**Response from the South Downs National Park Authority to the Examining Authority's written questions and requests for information (ExQI)**

The South Downs National Park Authority's (SDNPA) response to the questions asked of it are contained in the table below, against the Examining Authority's original question for ease of reference. These responses are provided for Deadline 1 of the examination (6 November, 2020).

**Application document reference 2.7
 Indicative Converter Station Area Layout Plans
 Option B(i)
 Sheet 2 of 3**

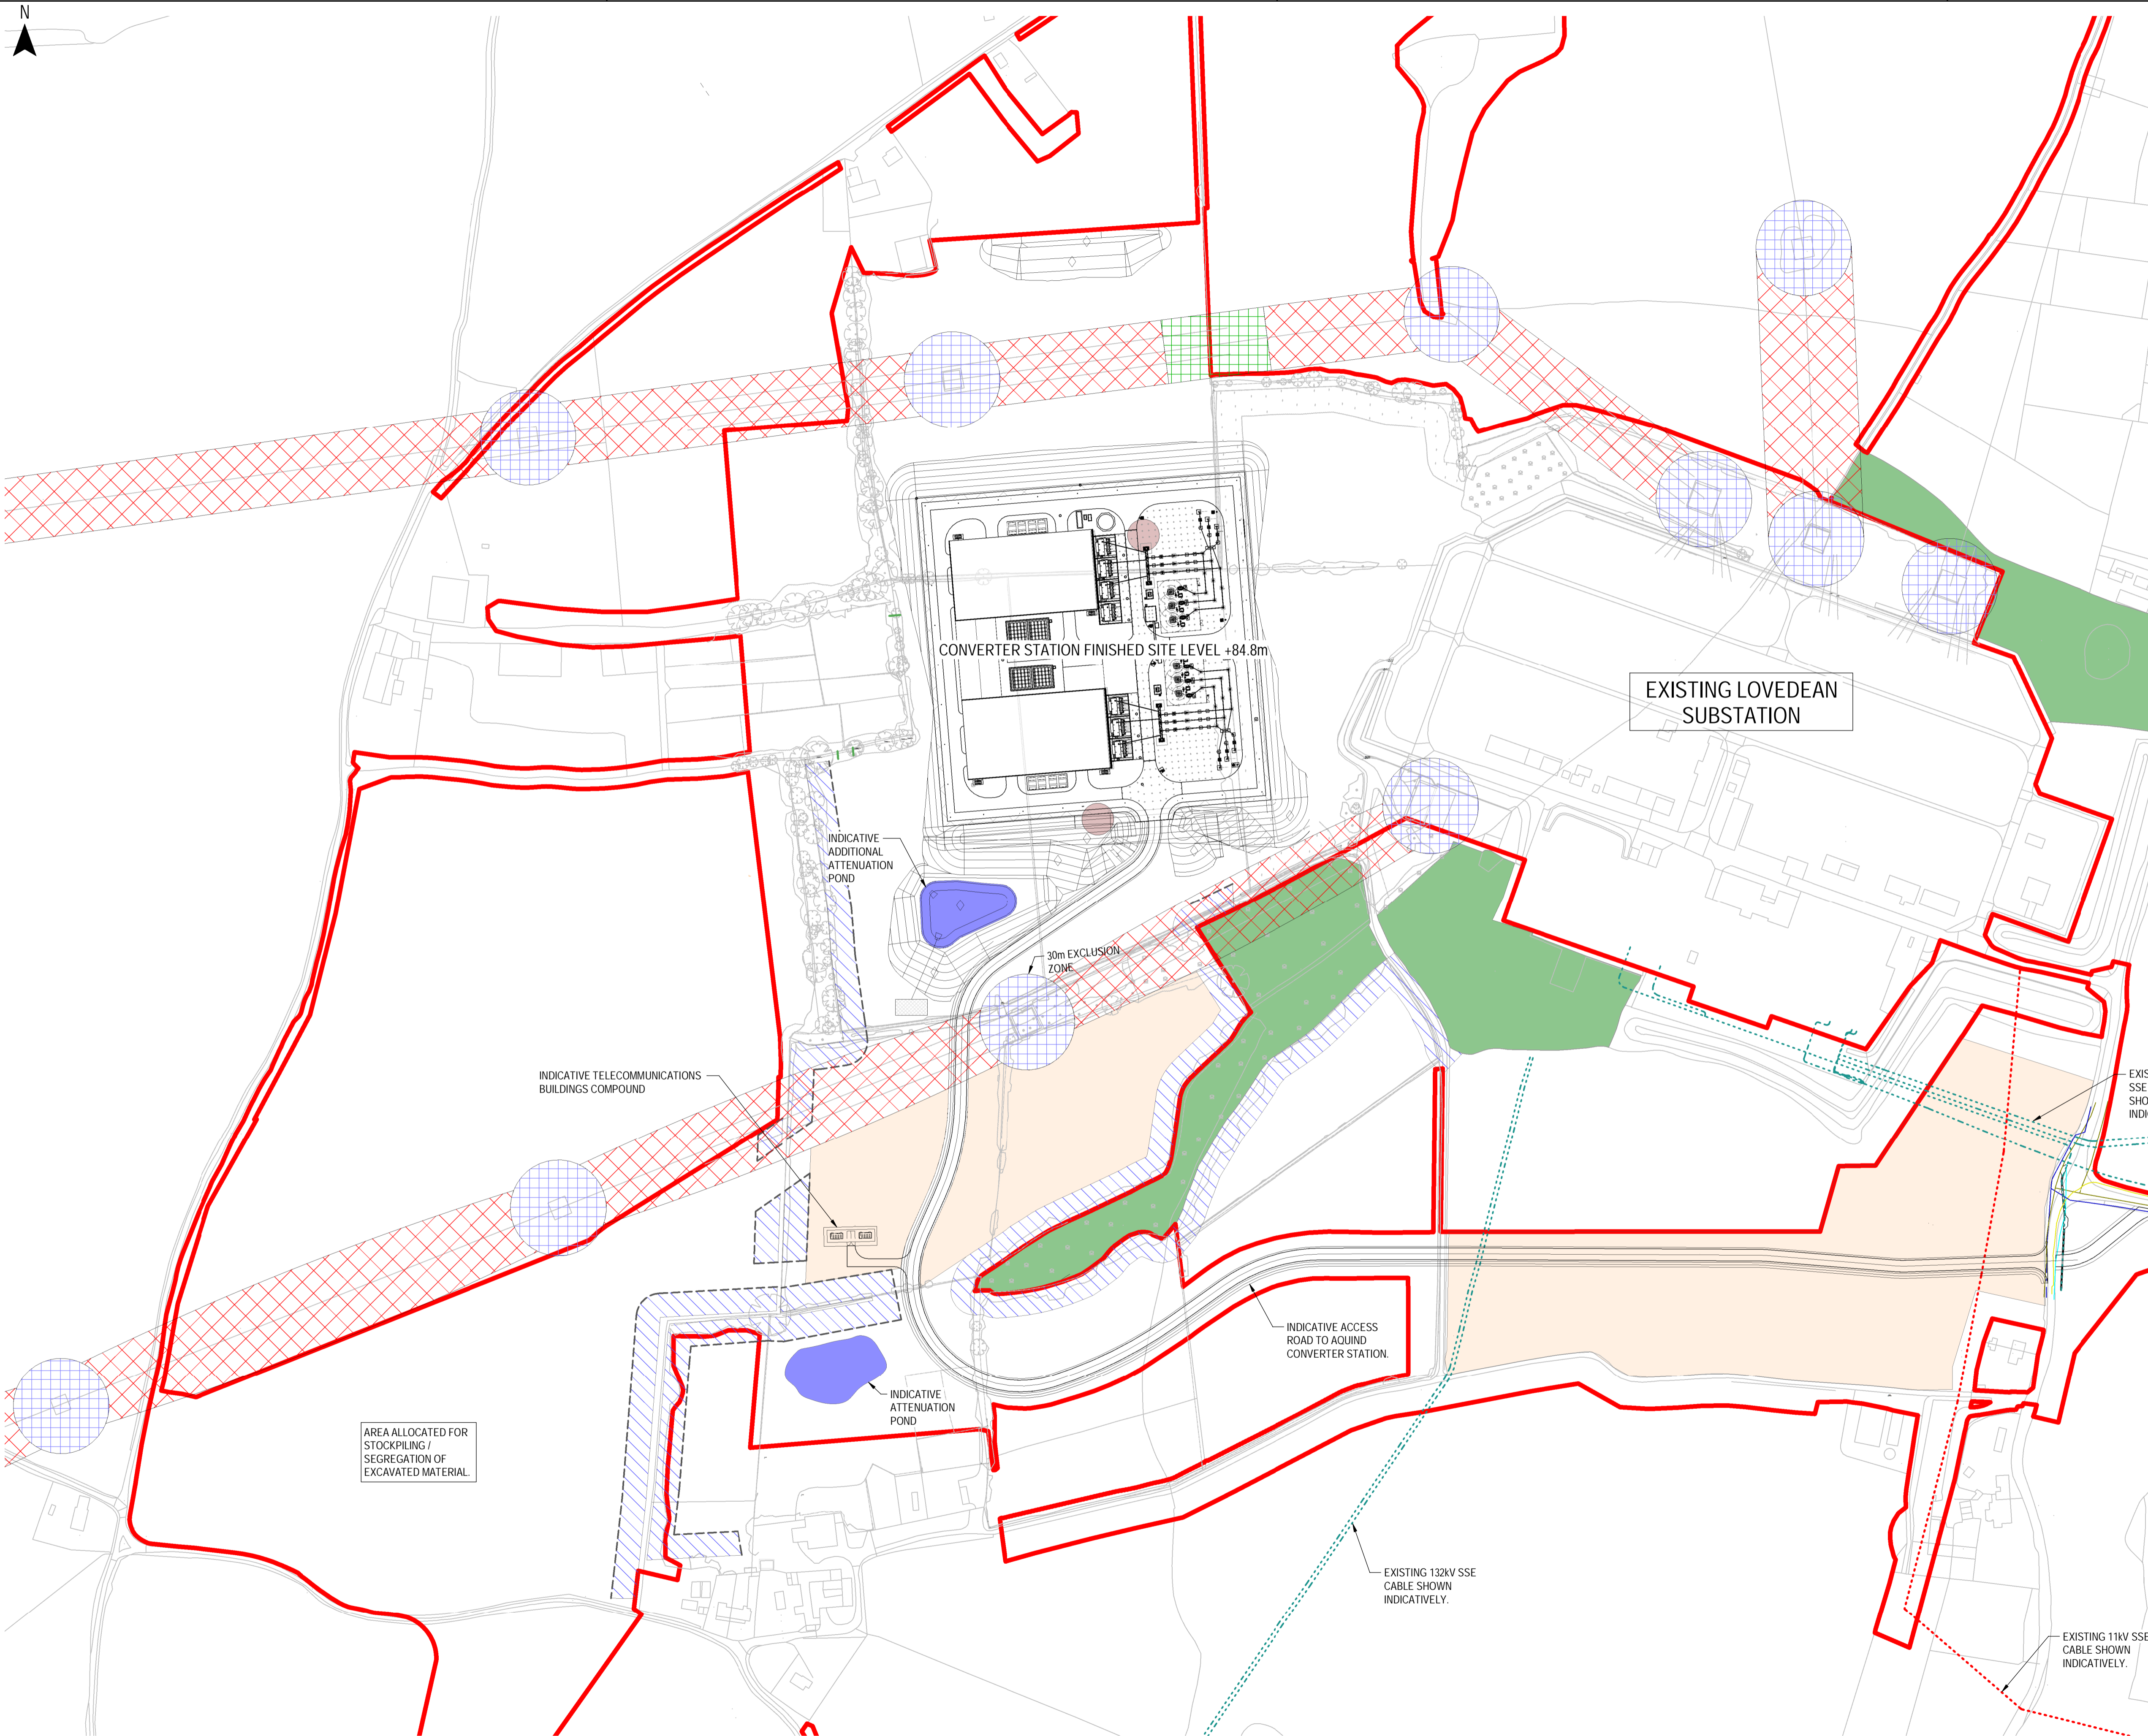
<p>‘National Grid is a Statutory Undertaker and therefore, as per section 62 of the Environment Act 1995, they are required to have regard to the purposes of the National Park in their decision making. It is not clear whether the assessment of alternatives (set out in the Environmental Statement Chapter 2: Consideration of Alternatives) by National Grid when preparing the NGET feasibility study in 2014 took into account the impact of the various options on the National Park. There is only limited information on how that duty has been met and the SDNPA will be seeking further information on this from National Grid.’</p> <p>Have negotiations continued and is there any update to report?</p> <p>Could the South Downs National Park Authority explain if, in its view, the Proposed Development would affect the statutory purposes for which the National Park was designated? Further, does it believe that there any distinction between the effects of Option B (i) and B(ii) in relation to their effects on the statutory purposes of the National Park?</p> <p>Please could NGET explain if and how you had regard to the statutory purposes of the South Downs National Park designation in preparing the 2014 feasibility study referred to in Chapter 2 of the ES [APP-117].</p>	<p>the natural beauty, wildlife and cultural heritage of the National Park.</p> <p>Without prejudice to our view that the Converter Station buildings cause harm to landscape character and the setting of the National Park the SDNPA prefers Option Bii) of the two options put forward by the applicant. This is because it retains a hedgerow and woodland to the west that we understand would be lost under option Bi).</p>

Figure 15.49: Indicative Landscape Mitigation Plan Option B(1) (south)

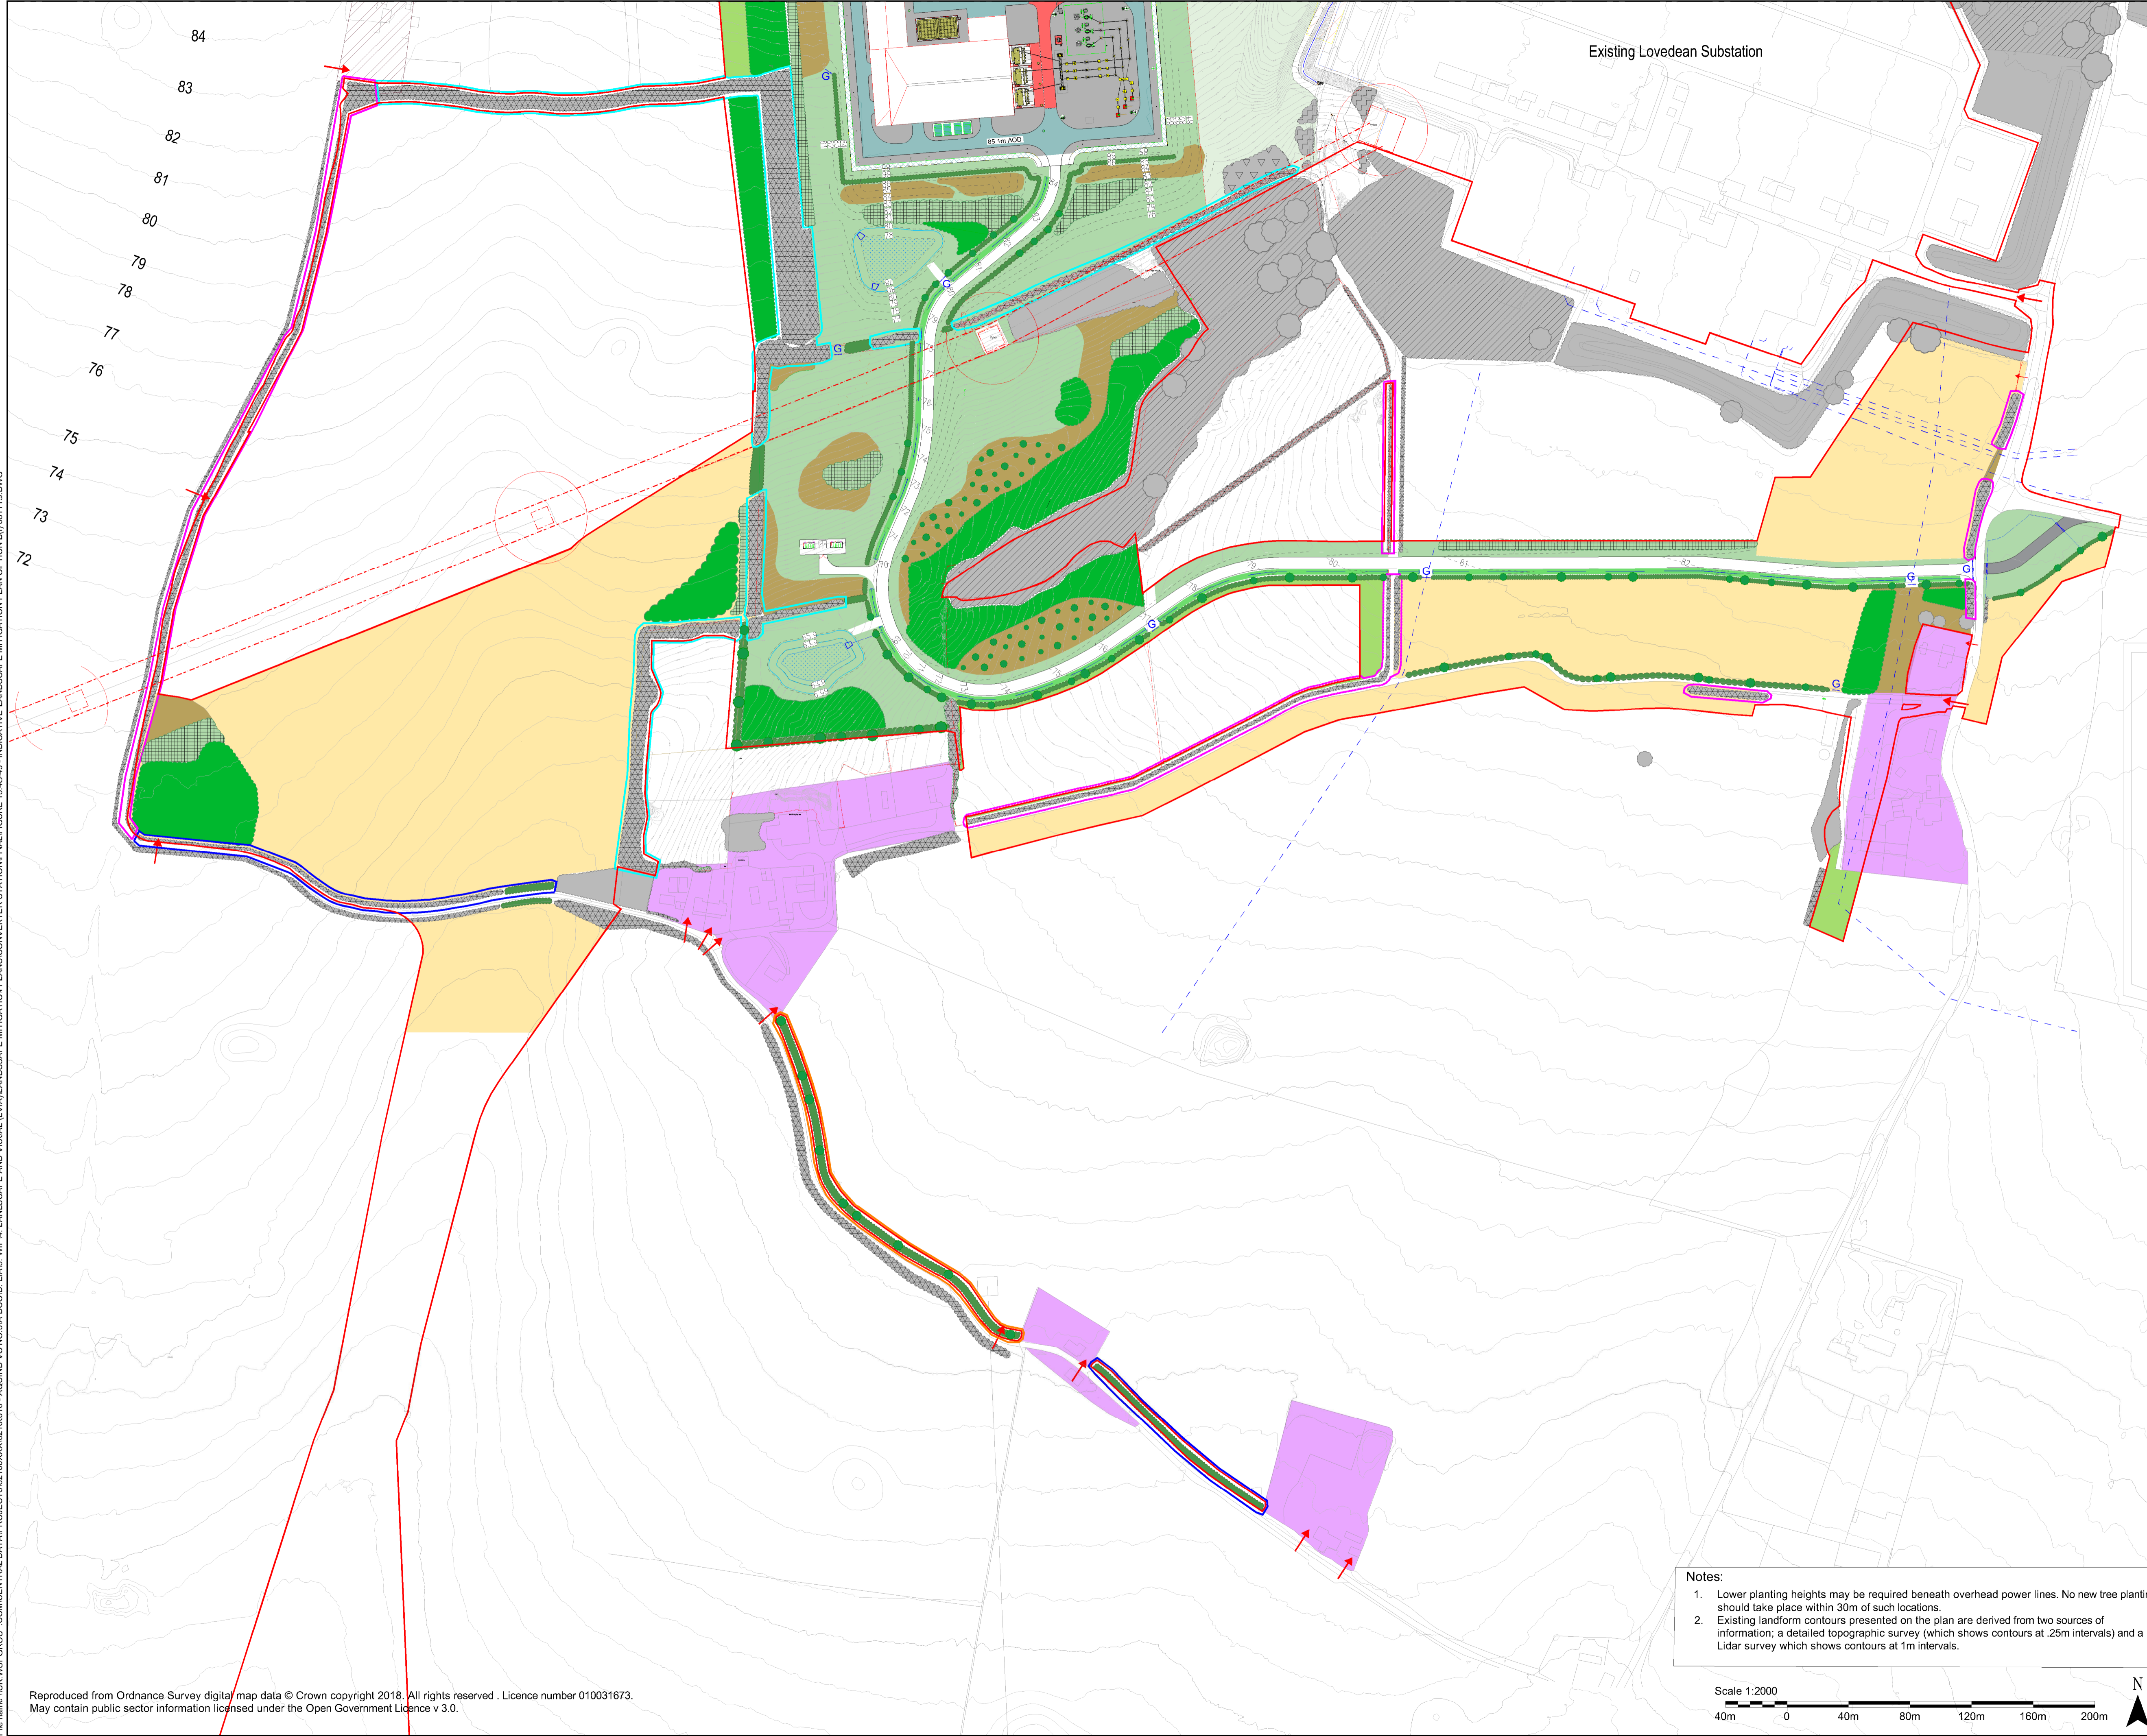
LVI.9.35	<p>Your Relevant Representation [RR-049] notes that you are still reviewing the landscape and visual mitigation proposals for the Converter Station. Could you please confirm your updated position?</p> <p>Are you satisfied with the Applicant's proposals [APP-130]?</p>	<p>We are not currently satisfied with the applicant's proposals on this matter but we are, and will continue to, work with the applicant to address these matters.</p> <p>Current issues we have with the landscape and visual mitigation proposals are:</p> <ul style="list-style-type: none"> <li>• In relation to the colour scheme for the proposed Converter Station buildings we do not consider the autumn spectrum to be sufficiently developed as a response to the context of</li> </ul>

<p>proposed building. In our view the building as it stands is imposing and dominant in colour appearing over the top of mature tree and woodland belts. We have asked the applicant to carry out further work on this (which they have agreed to) thus this matter is still under discussion.</p> <ul style="list-style-type: none"><li>• It appears that not all of the proposed landscape mitigation areas are in the applicant's control so we question how it will ensure continued management for the purposes of mitigation.</li><li>• In addition no assessment appears to have been made of the age, condition or species of trees in the existing areas to be used for mitigation.</li><li>• There is a lack of a proactive strategy to deal with Ash die back</li><li>• The limitations on woodland planting along the perimeter security fence are acknowledged, however this does not preclude more significant woodland planting further away (which unfortunately has not been proposed).</li><li>• Hedgerows which accentuate the line of the proposed access drive (and which cut across field boundaries) should be more closely aligned with the existing field pattern.</li><li>• The treatment of the western/northern boundary is very rectilinear in contrast to the surrounding field patterns &amp; will not provide a seamless interface between the new and the existing landscape pattern.</li><li>• Regarding the sizes of tree nursery stock at planting – we consider that there is a need to have a much bigger range of planting sizes than currently proposed to achieve screening at an earlier stage.</li><li>• We also consider that standard, heavy standard and extra heavy standard trees should be included in the woodland blocks (not only as specimen trees) to broaden the age of the stand, increase the range of canopy height and provide</li></ul>
